From: Matthew Fish <Matthew.Fish@sunderlandpeacock.com>
Sent: 07 February 2019 17:51
To: Adrian Dowd
Cc: hazel marchant; Philip Cottier
Subject: RE: Application 3/2018/1014 - 5 Gisburn Road, Bolton by Bowland
Attachments: Proposed Externals P-03 REV D.pdf; Proposed FF P-02 REV D.pdf; Proposed GF P-01 Rev D.pdf

Application 3/2018/1014
5 Gisburn Road, Bolton by Bowland

**PROPOSED ALTERATIONS TO
No 5 and 7 GISBURN ROAD
BOLTON BY BOWLAND
LANCASHIRE**

PROPOSED EAST FACING ELEVATION

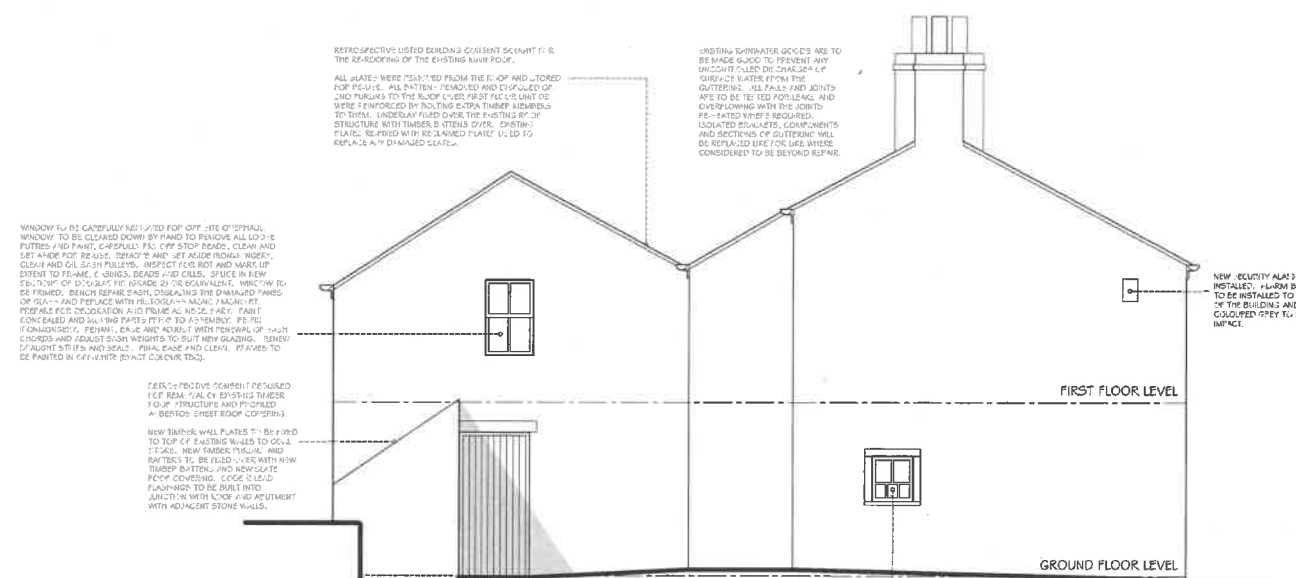
Little information has been submitted to describe or justify the proposed removal of existing (mainly front elevation) windows and replace with modern double-glazed side-opening casements. I also note that the ground floor window on the drawing ‘Proposed East Facing Elevation’ is proposed as a side-hung casement – is this opening mechanism like-for-like?

4. The existing windows proposed for replacement are a modern intervention and are of poor quality and crudely made. It is the intention of the applicant to install new timber windows of similar appearance and with new single glazing of much higher performance and quality standards thus providing an enhancement to the appearance of the listed building and its performance i.e. energy efficiency. Our aim is to increase the amenity of the building and enhance the building in terms of its use and environment whilst providing a comfortable place to live. The new windows are traditional in appearance and sympathetic to the character of the listed building and conservation area. The ground floor window to the east facing elevation has been amended and will be a fixed window as a per existing.
